Arun District Council
Arun Civic Centre
Maltravers Road
Littlehampton
West Sussex BN17 5LF
Planning & Building Control General Enquiries
Tel: (01903) 737756 Fax: (01903) 730442
Dx: 57406 Littlehampton
Minicom: 01903 732765
e-mail: planning@arun.gov.uk
website: www.arun.gov.uk/planning

Application No: BR/8/21/RES
Site Address: Richmond Arms 224 London Road Bognor Regis PO21 1AU
Description of works: Approval of reserved matters following BR/142/18/OUT for the demolition & conversion of existing public house with residential accommodation to 1st floor to form 10 No. residential flats over 3.5 storeys.

Thank you for your internet representation made on 26th February 2021 which has been recorded as an objection with the comments as follows:

ROOF PLAN

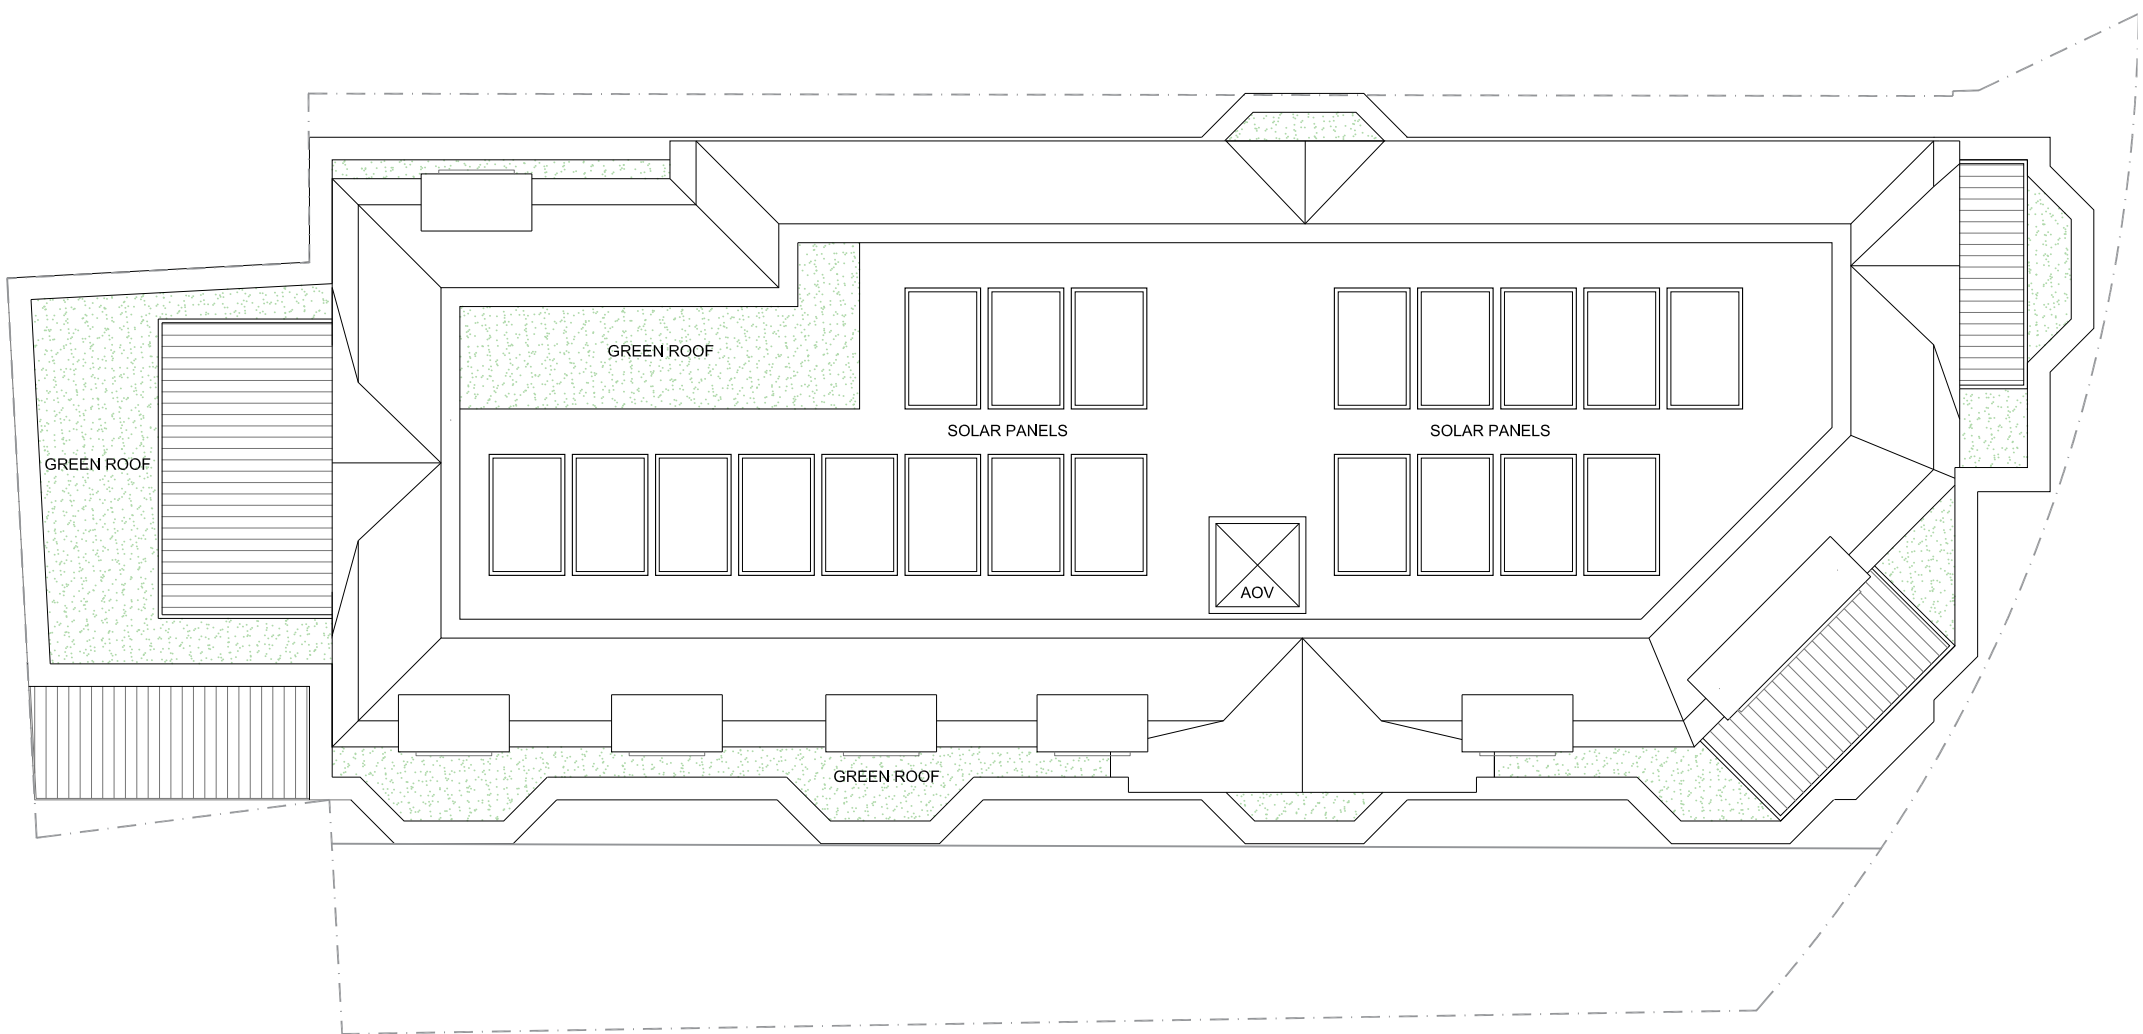
over development in immediate areas, should be reduced from 10 to 6 apartments. Over viewing 2 properties to the east from windows & from roof terrace platform, doors & windows will be an intrusion of privacy's The light illumination from all windows will have a negative effect on the area & the 2 properties to the east. The eastern boundaries of development have encroached onto public community garden which needs access for maintenance work - this was an issue which was objected & should have been noted when application was first submitted! Reduce 10 to 6 apartments, proposed development too high, windows overlooking 2 properties to the east end of development, proposed roof terrace facing east overlooking the 2 properties too invasive!
